EL PASO COUNTY GRADING AND EROSION CONTROL PLAN CHECKLIST

EPC Project Number: **PPR2417**

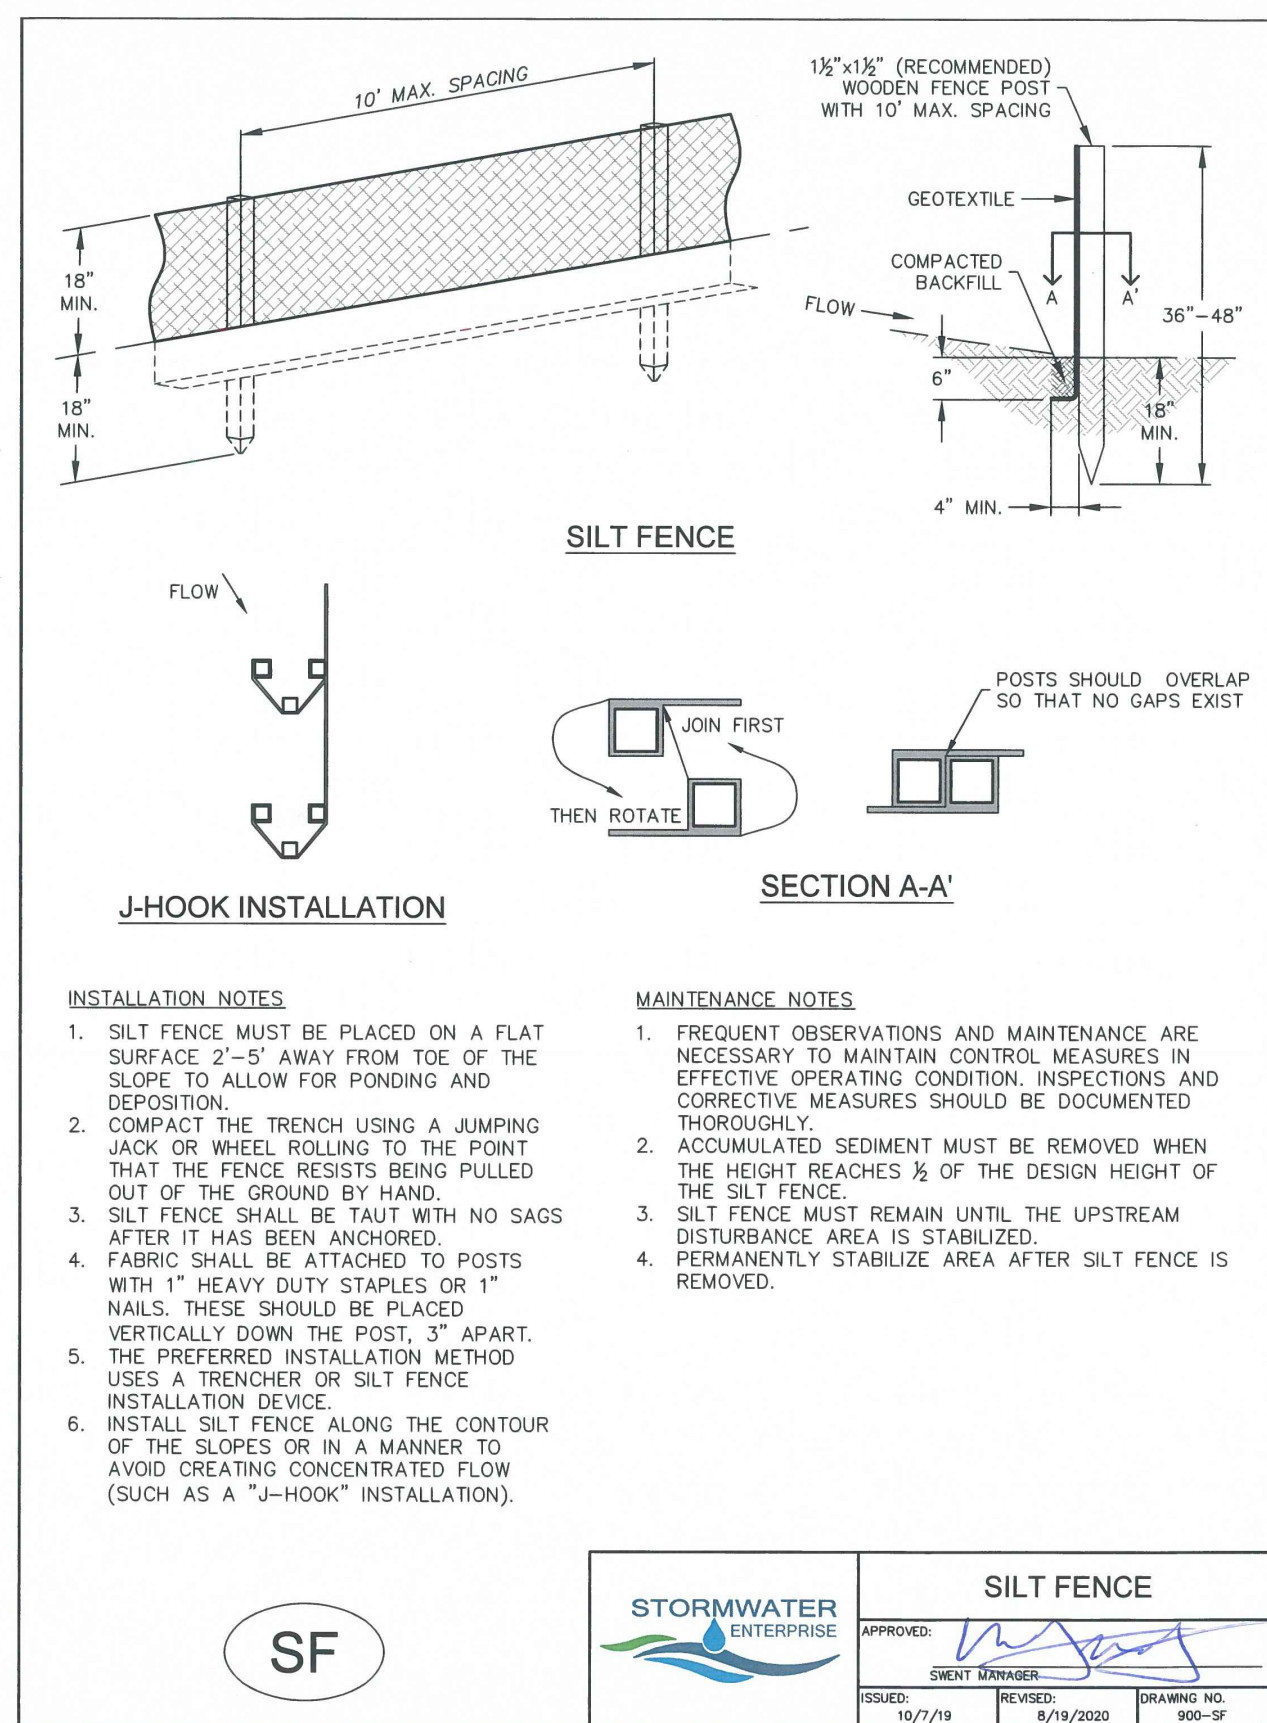
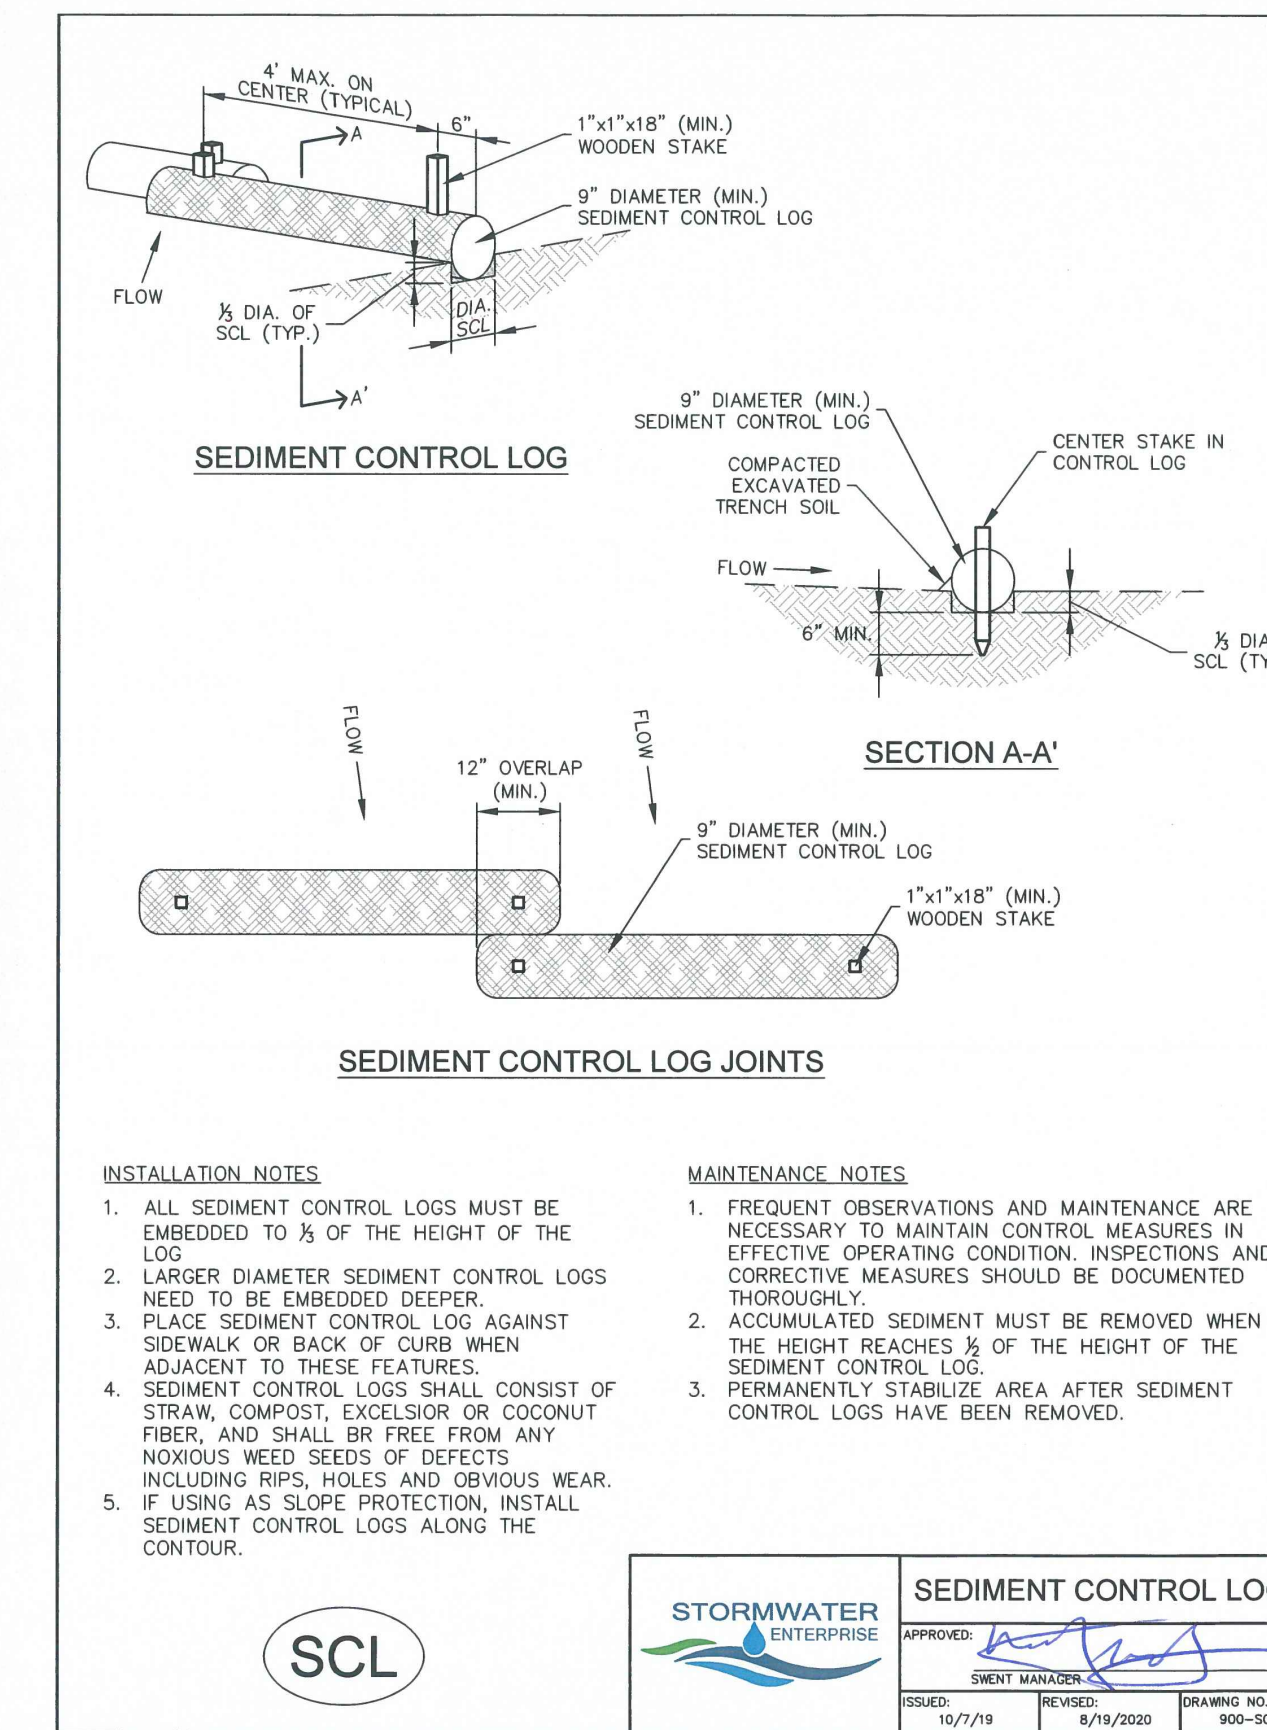
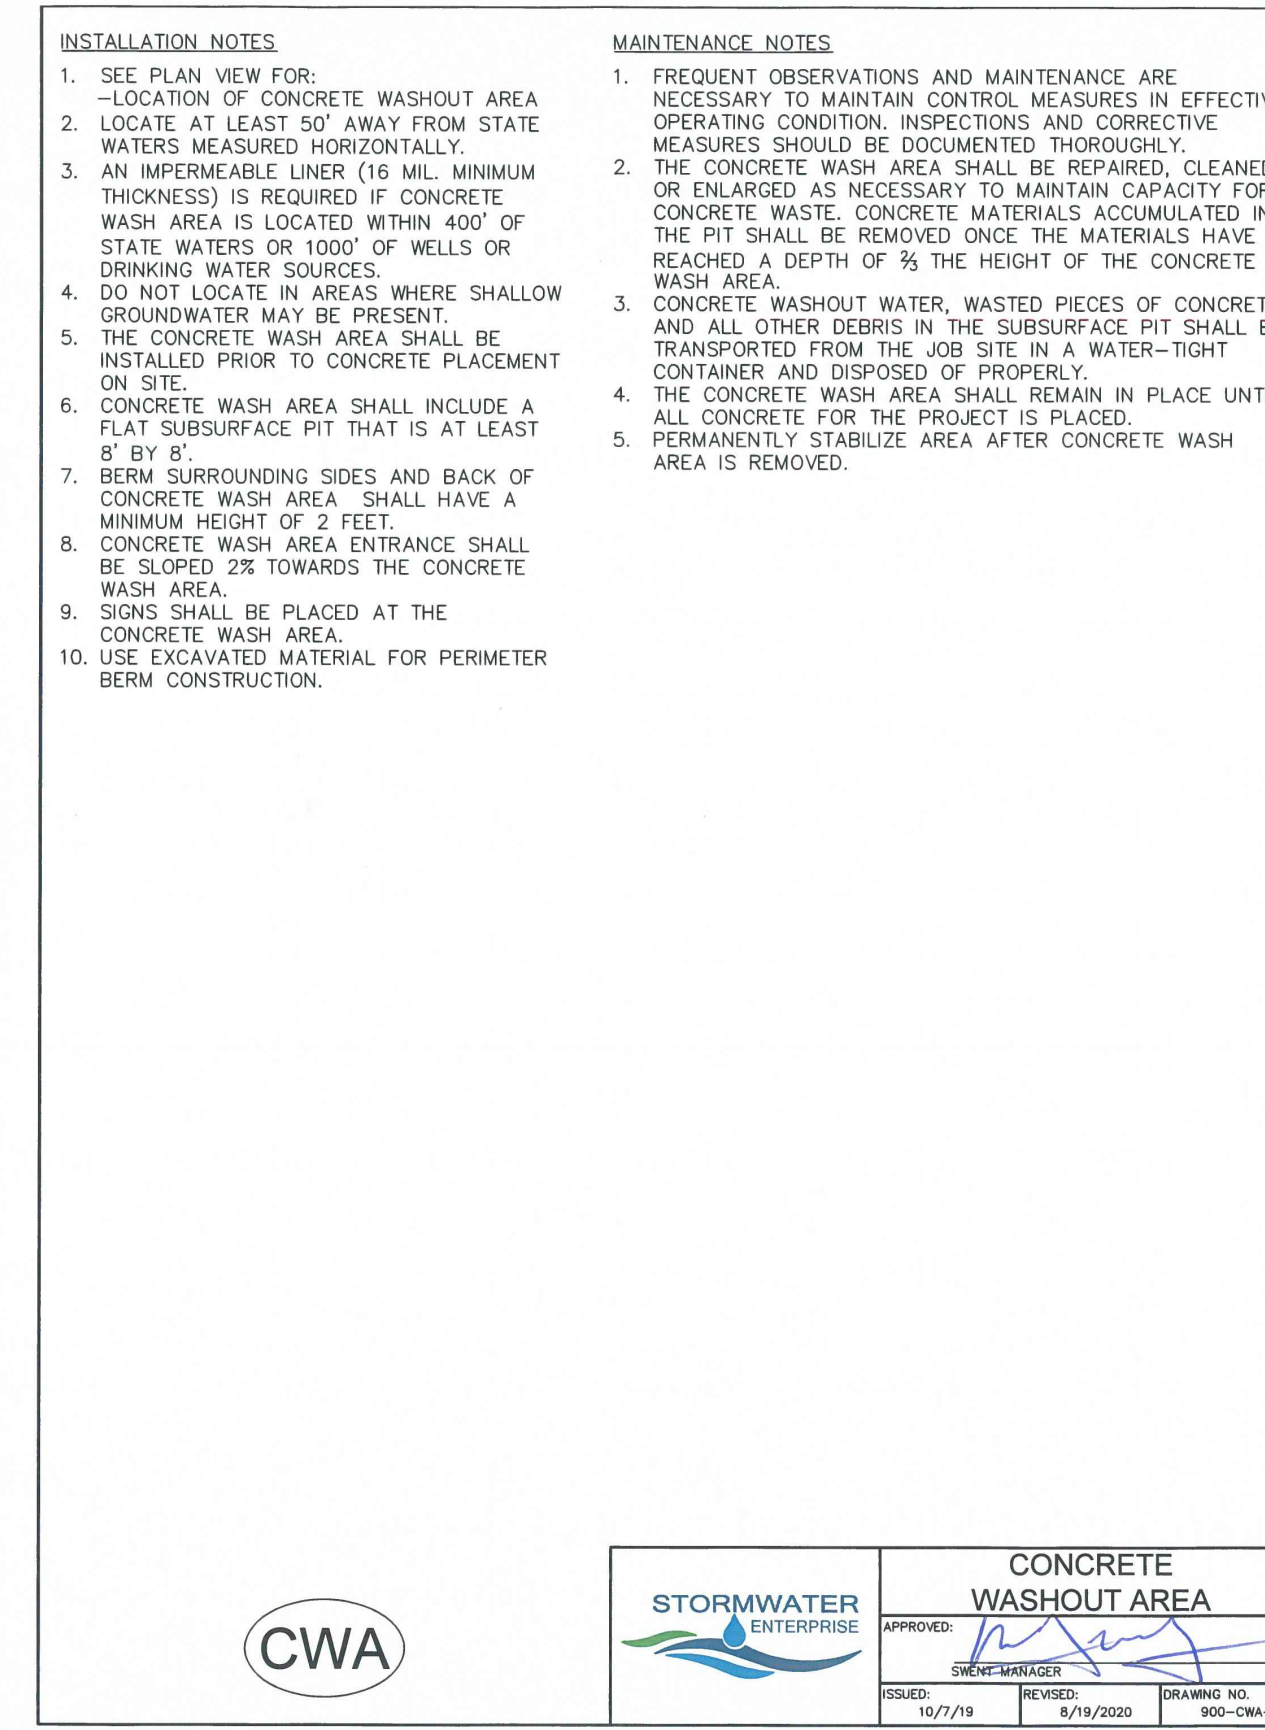
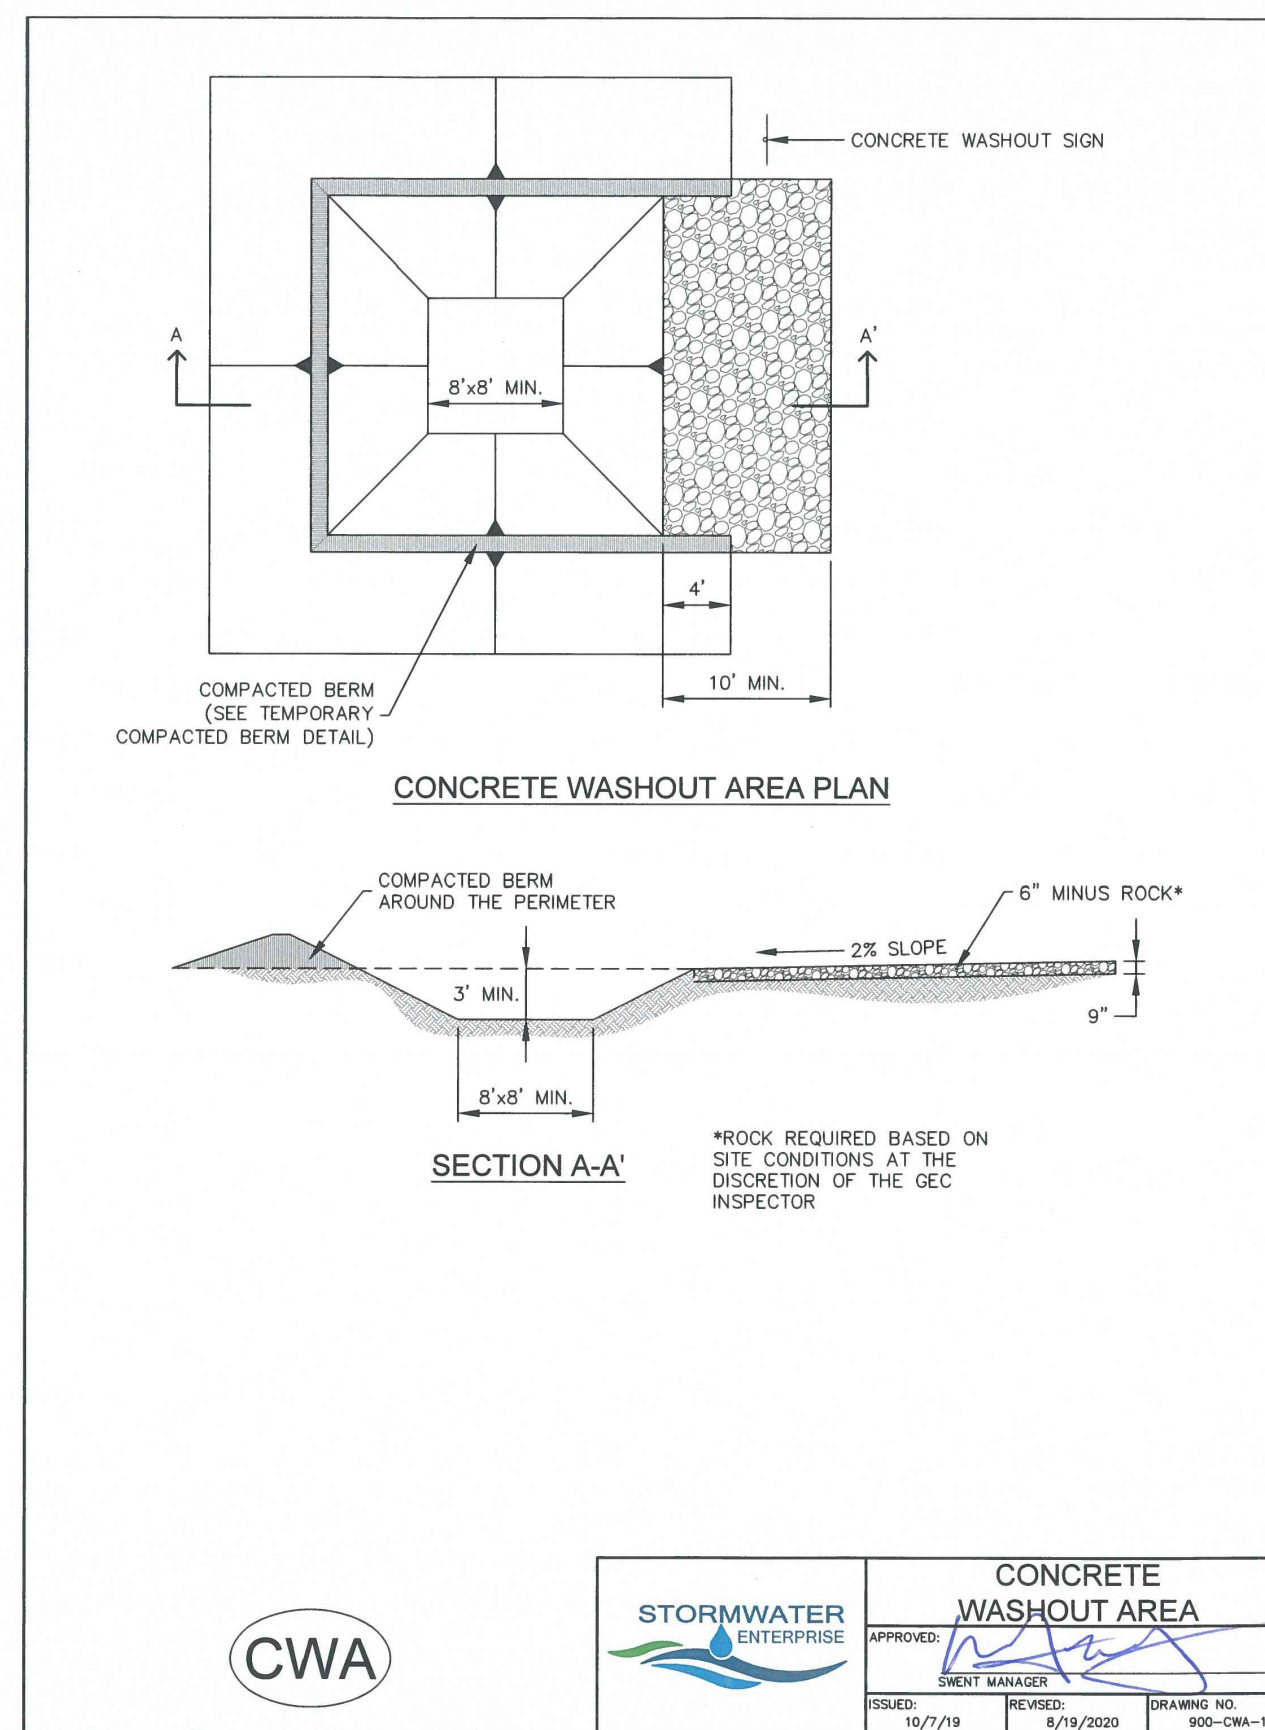
| | | Applicant | EPC |
|----|--|-----------|-----|
| z | All proposed temporary construction control measure details. Custom or other jurisdiction's details used must meet or exceed EPC standards | | N |
